Charlotte Department of Transportation

Memorandum

Subject: Rezoning Petition 08-139: Located on the north side of Ballantyne Commons Parkway between Rea Road and Williams Pond Lane (*revised 10/24/08*)

SITE PLAN

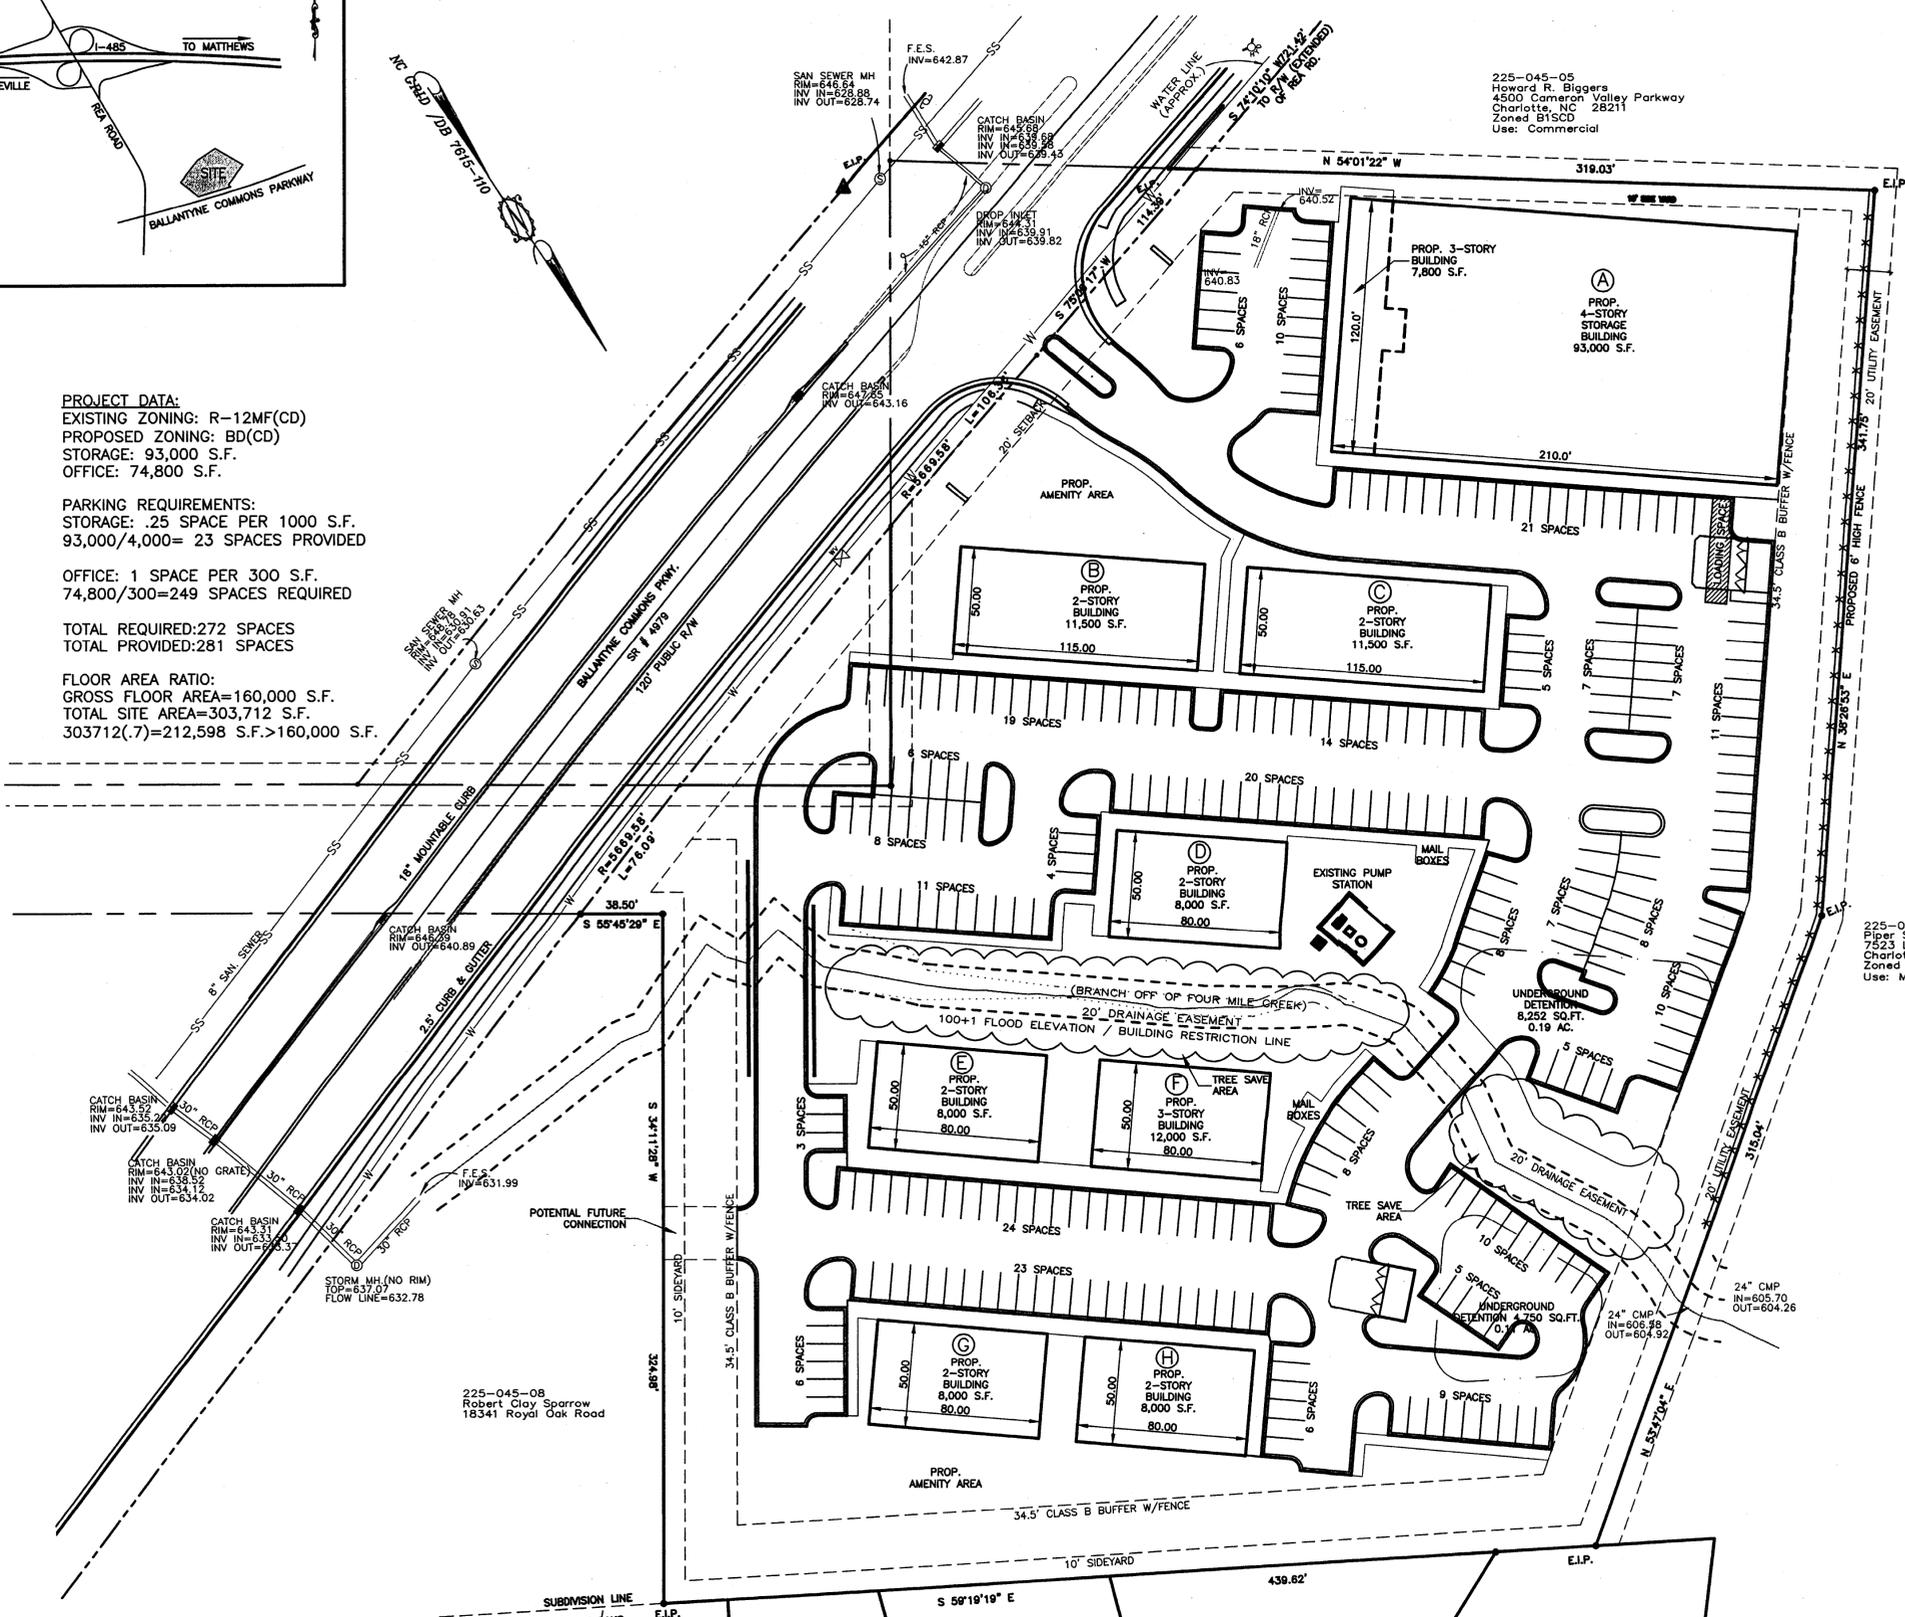
We have no further transportation issues with this petition provided that the clarifying cross access easement revisions are made to the site plan as agreed to by the petitioner's agent on October 29th.
